**Submission - SSD-13166280 Blind Creek Solar Farm - EIS Public Exhibition –  
Council Ref: PR.2022.1018**

Thank you for the opportunity to provide comments on the EIS for the Blind Creek Solar Farm Project at Bungendore. Council's comments are as follows.

(b) Example Single-Axis Tracker Profile (±62° Tilt)

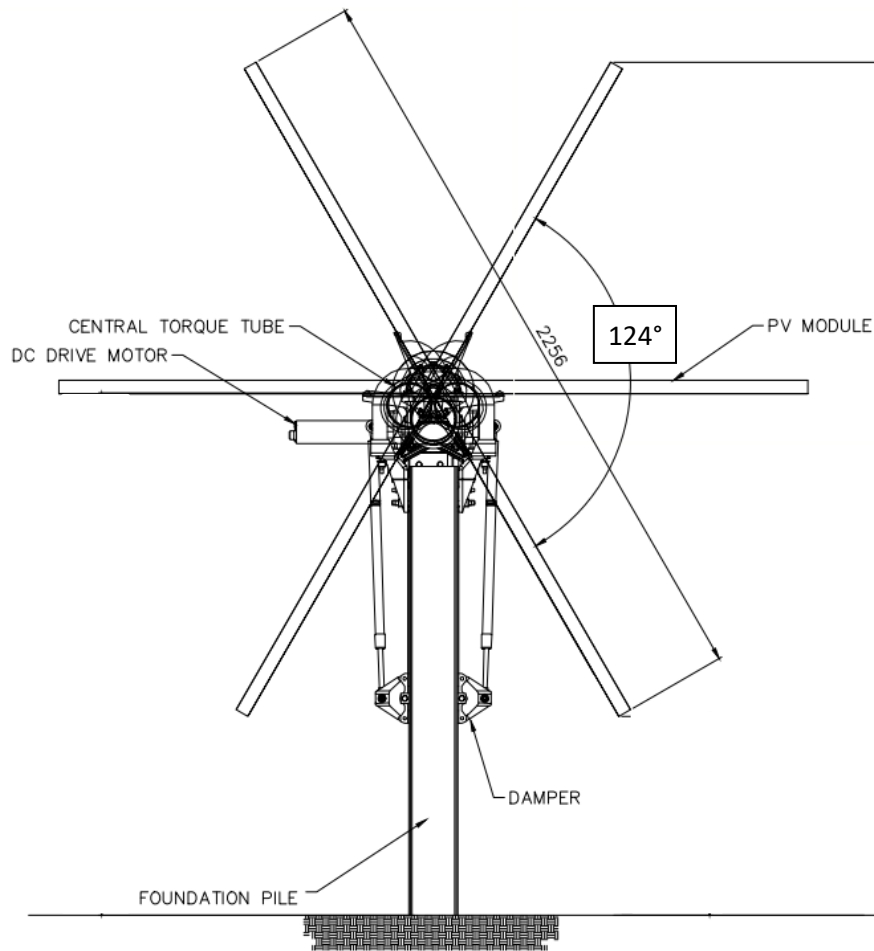
- Residential nuisance glare section 6 (pages 31 – 41) should also reference the future residential areas of Bungendore as identified in the [Bungendore Structure Plan 2018-2048](#).
- The EIS should require confirmation that the panels in the facility will be operated in tracking mode (Pages 12, 17 and 41).
- Require confirmation that the airstrip will be decommissioned (Pages 3, 20-24 and 47).
- Require confirmation about the proposed night time lighting of the development (Pages 45 – 46).
- 24hr lighting of the development is not supported (Pages 5, 12, 45, 48).
- Require confirmation on whether 2P trackers will be used, noting that this will result in an up to 5m higher tilt (Pages 5, 12 and 49).

### OSOM Swept Path Assessment

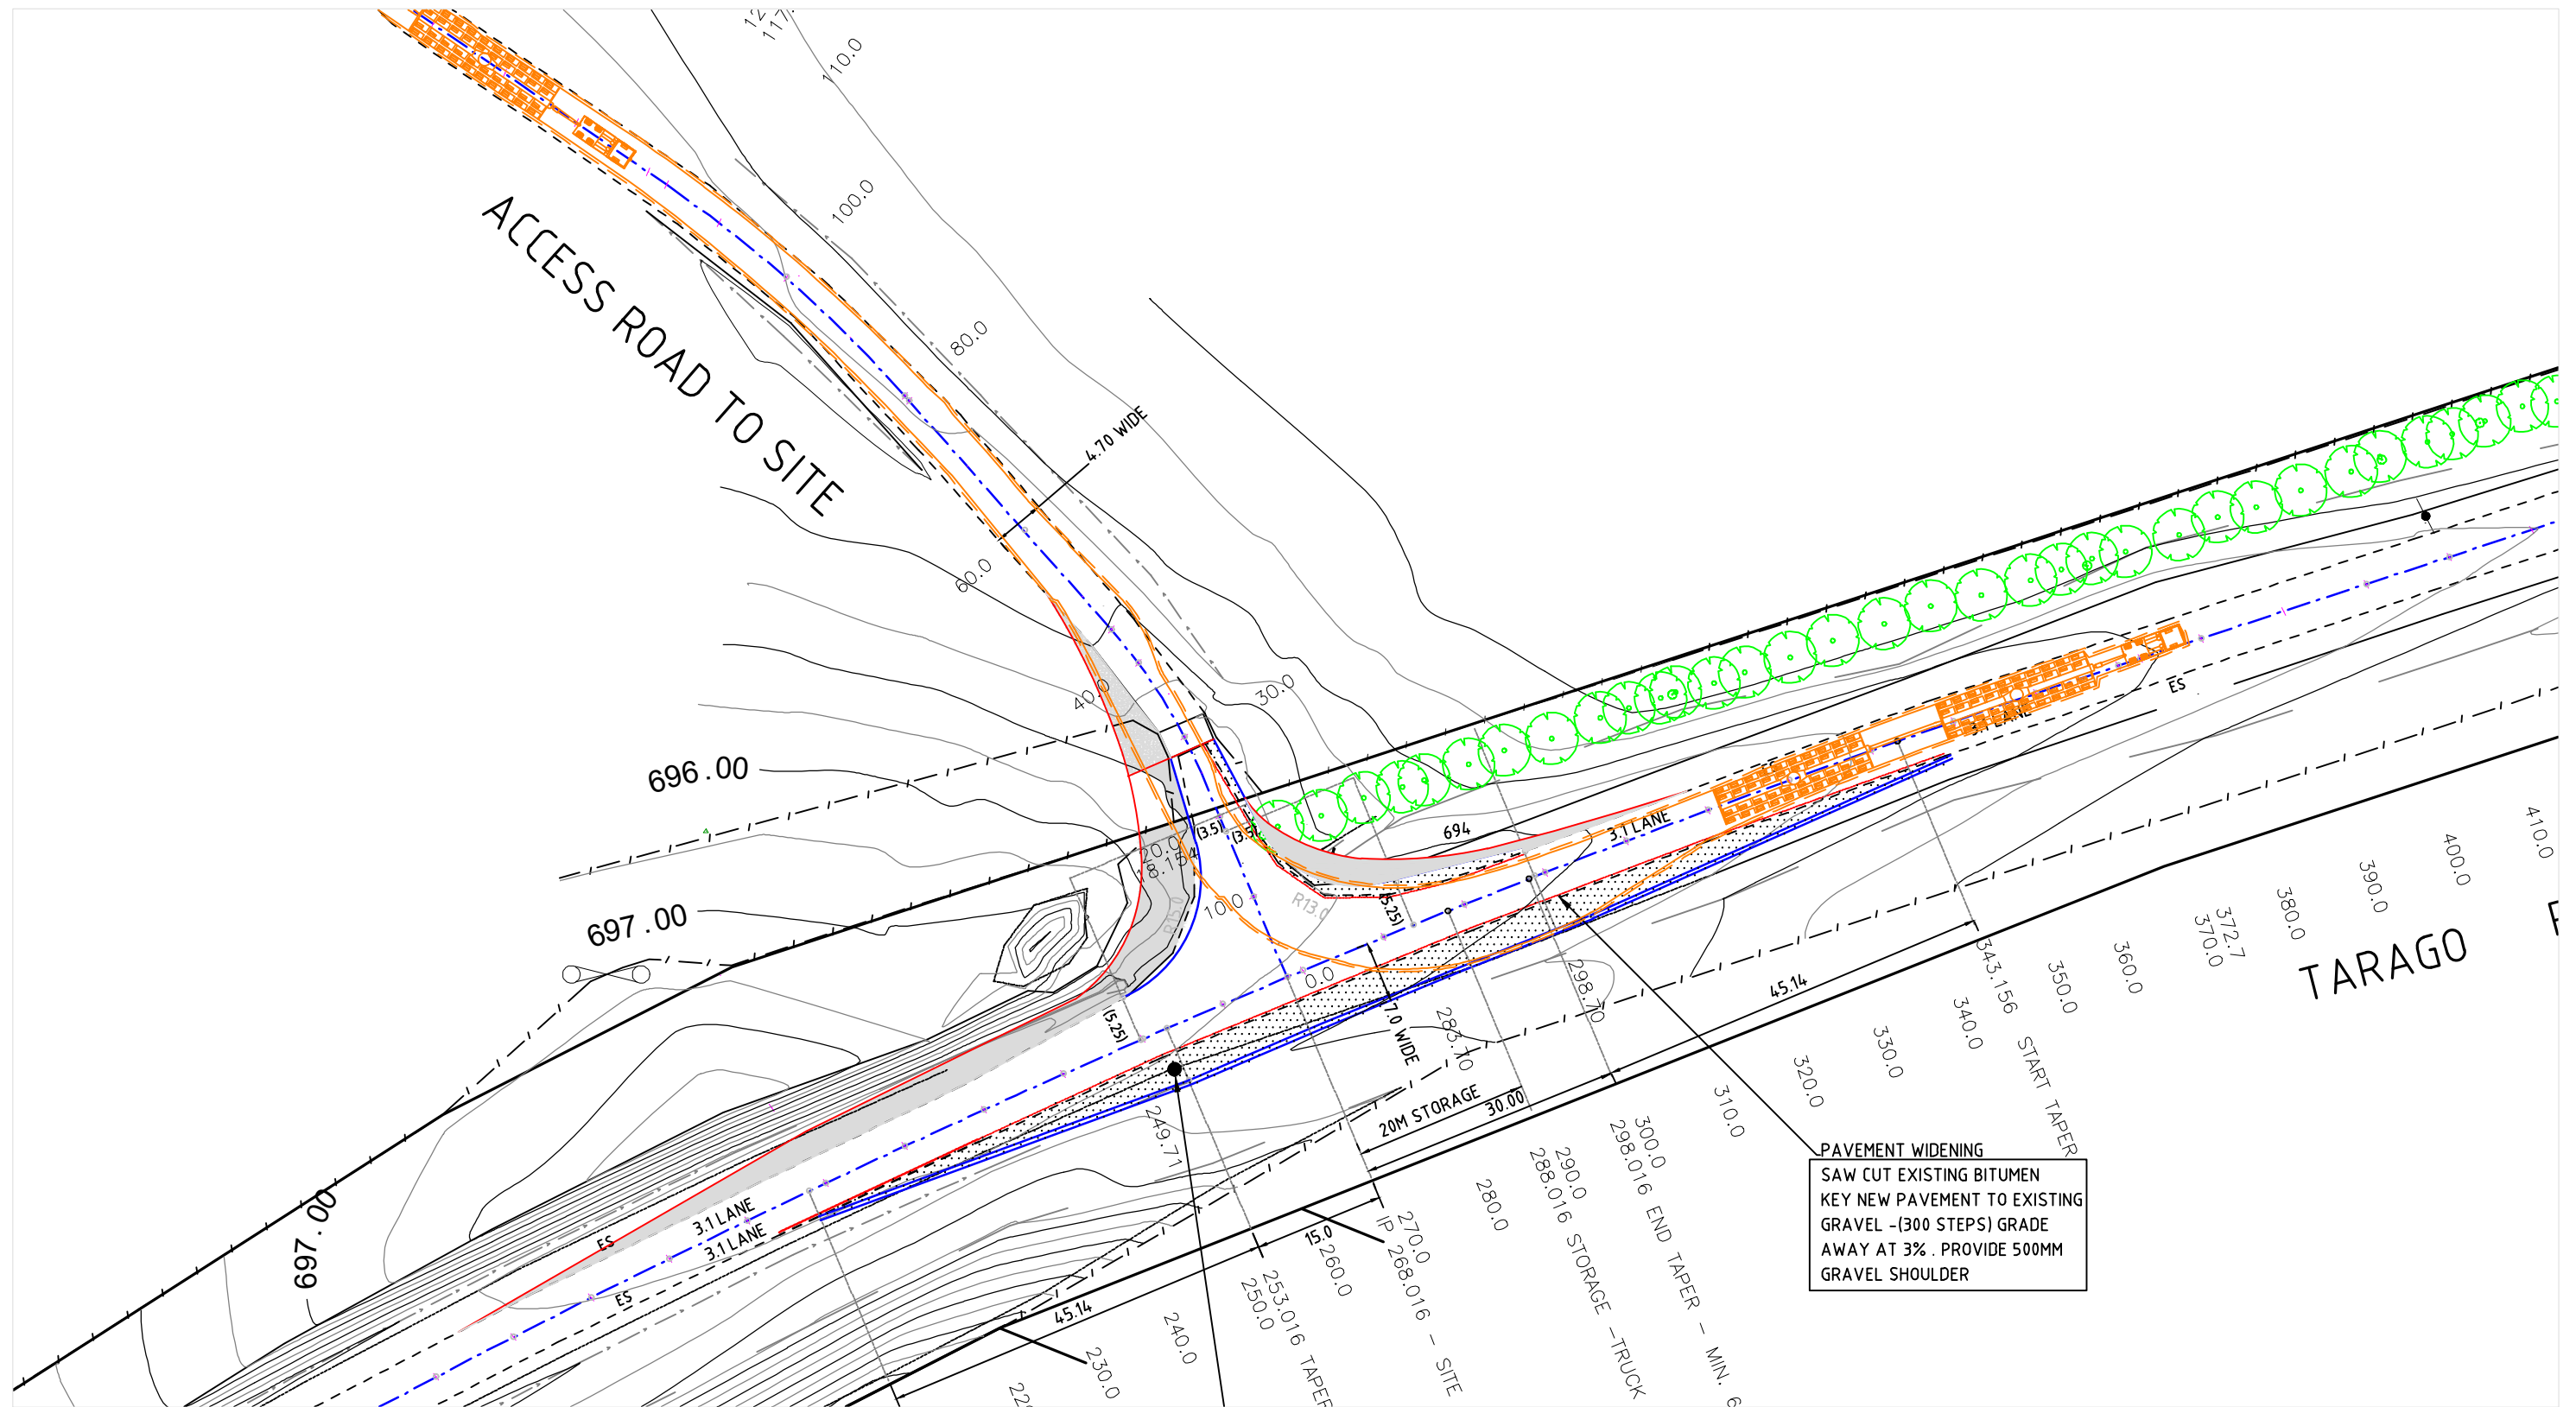
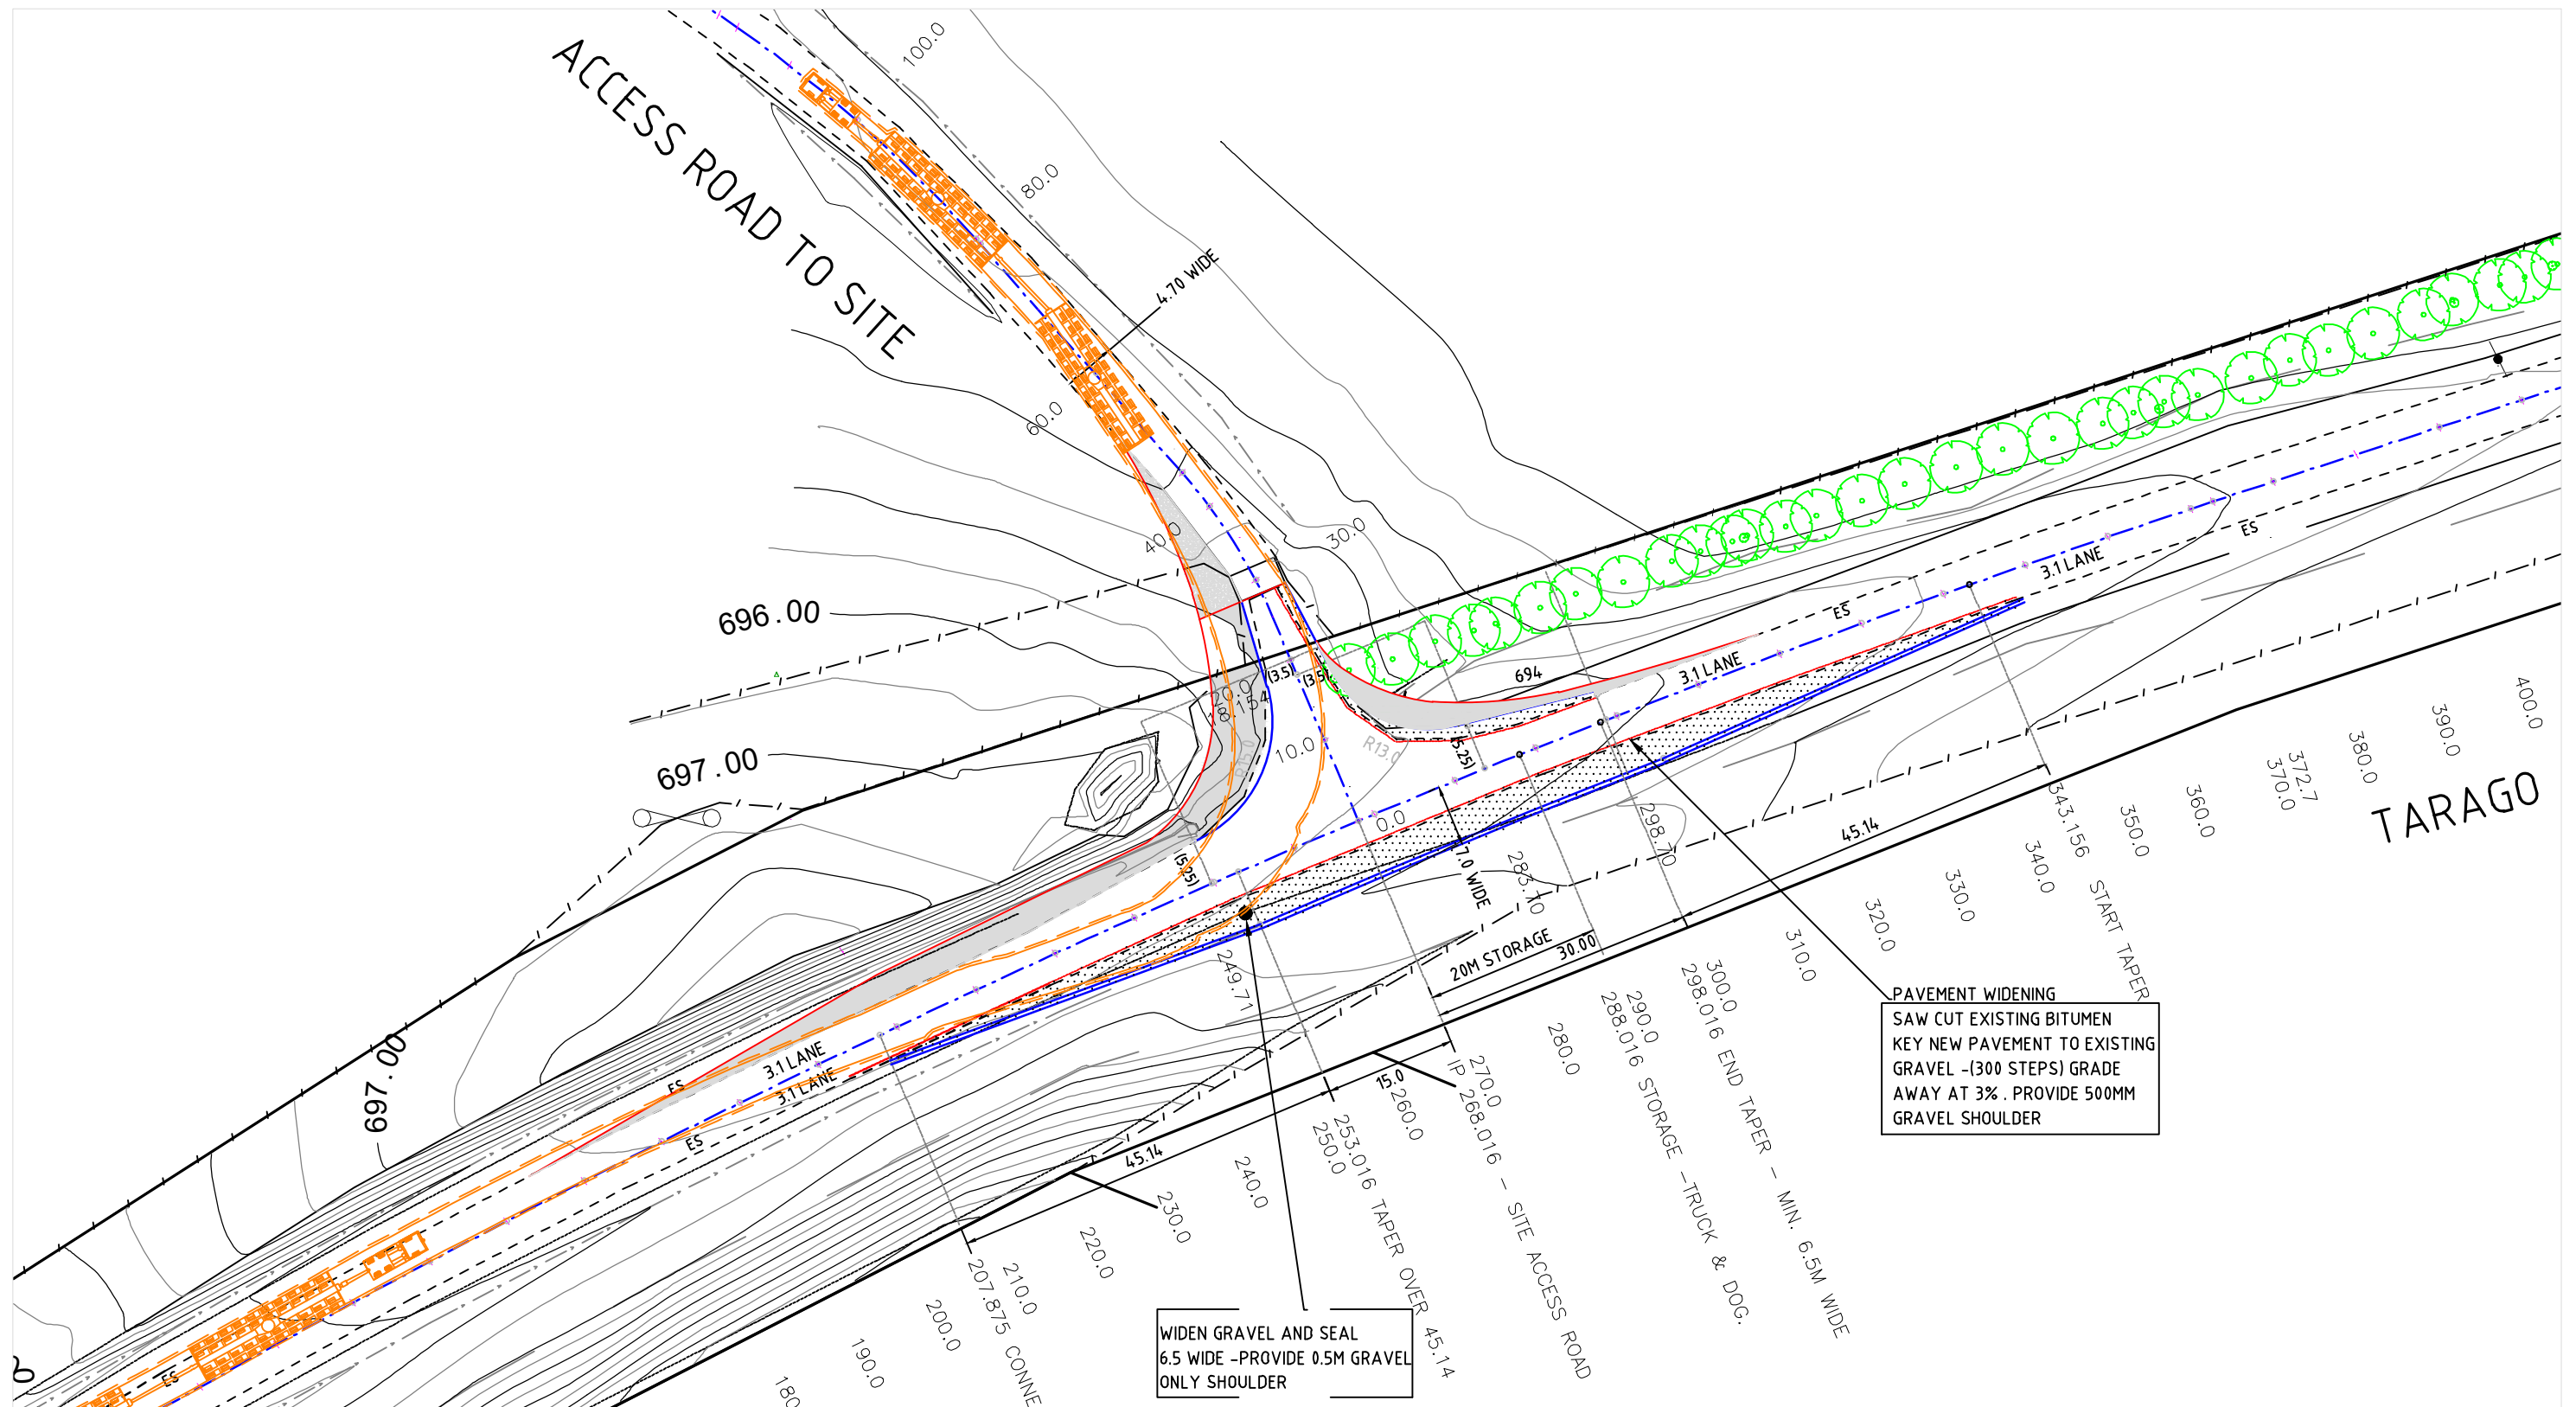
4. The OSOM (Over-size / Over-mass) vehicle described in the swept path assessment appears to be a vehicle that will require a police escort as part of any approval to operate on the subject road network.
5. The traffic impact assessment is generally constrained to Tarago Road without sufficient consideration and assessment of the impact on other nearby roads.
6. The assessment does not address financial reparations for damage to the road caused by the increased construction traffic associated with the development.
